# DRB CASE ACTION LOG (PREL & FINAL)

DRB Application No.: <b>07DRB-00348 (P &amp; F)</b>	Project # <b>1005449</b>
Project Name: <b>ACADEMY KNOLLS</b>	
Agent: <b>SURVEYS SOUTHWEST LTD</b>	Phone No.: <b>998-0303</b>

**RE: Tract AK-1, Academy Knolls/minor plat**

PLAT OF  
**TRACTS AK-1-A & AK-1-B**  
**ACADEMY KNOLLS SUBDIVISION**  
 PROJECTED SECTION 3, T. 11 N., R. 4 E., N.M.P.M.  
 ELENA GALLEGOS GRANT  
 CITY OF ALBUQUERQUE  
 BERNALILLO COUNTY, NEW MEXICO  
 FEBRUARY 2007  
 SHEET 2 OF 2

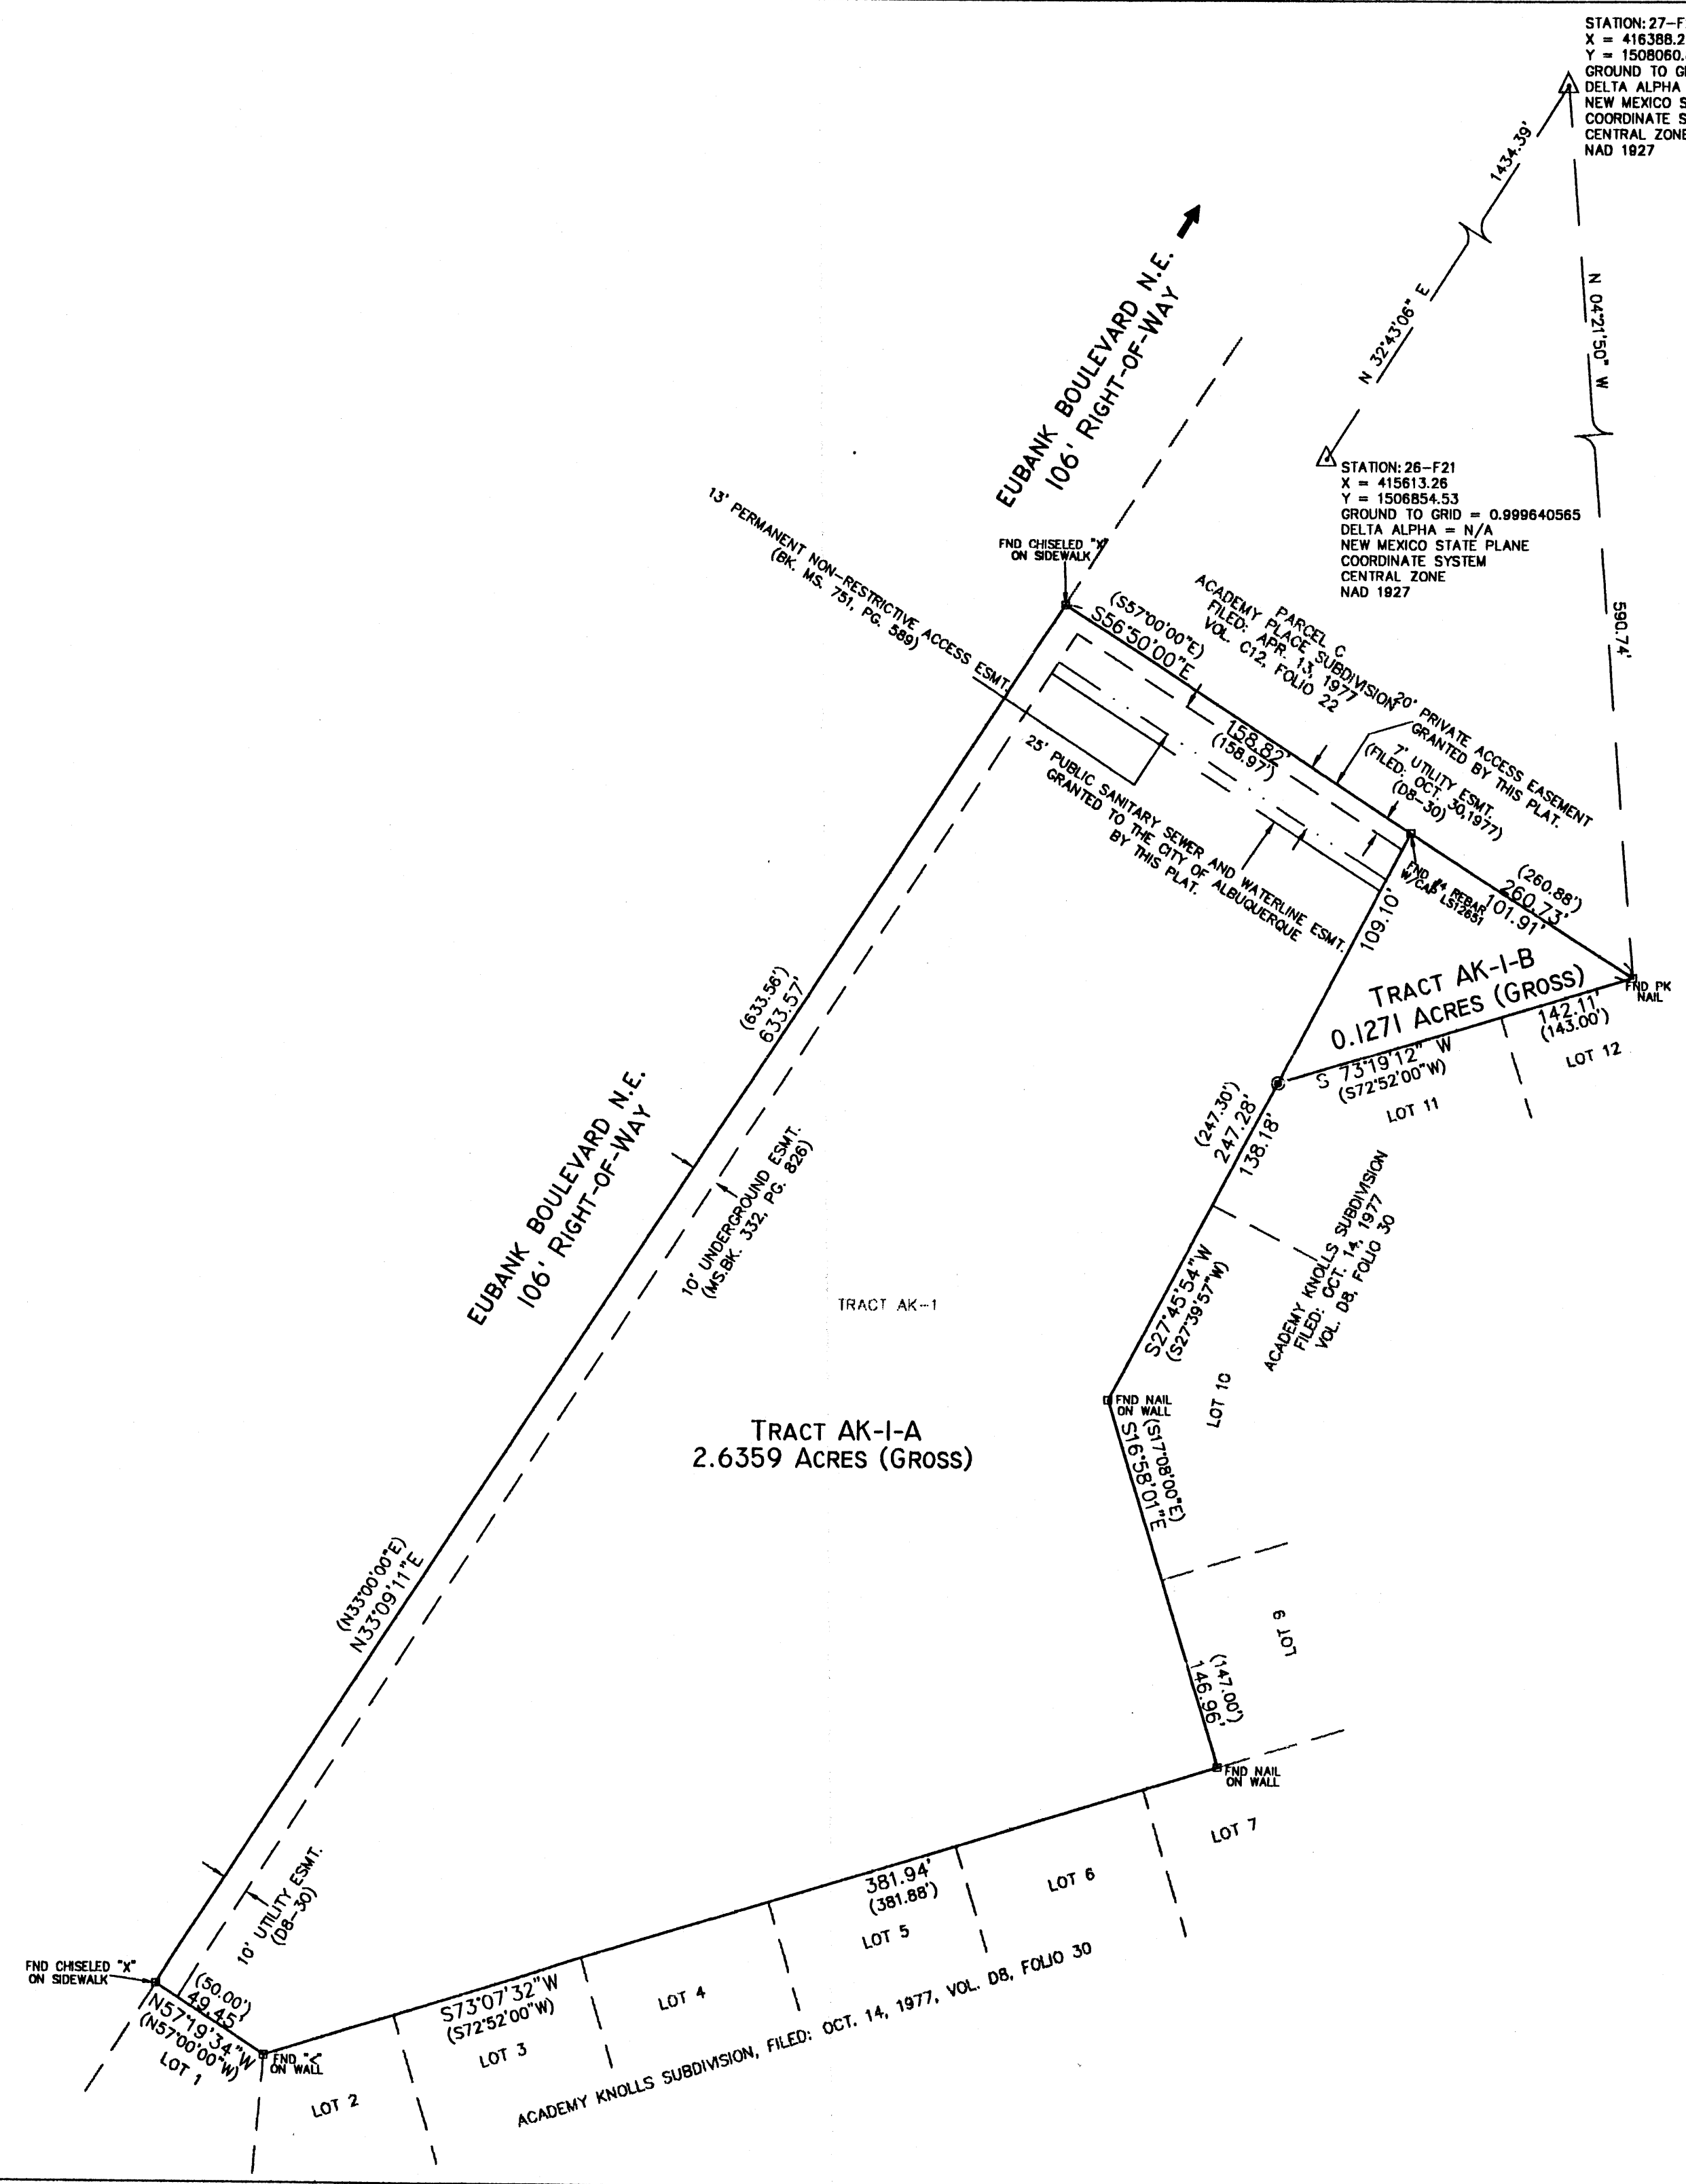
UTILITIES: Add 7' private access easement  
Add 25' public water/sewer easement  
Signature of ABCWUA Director on plat as owner

A cross lot drainage easement may be required.
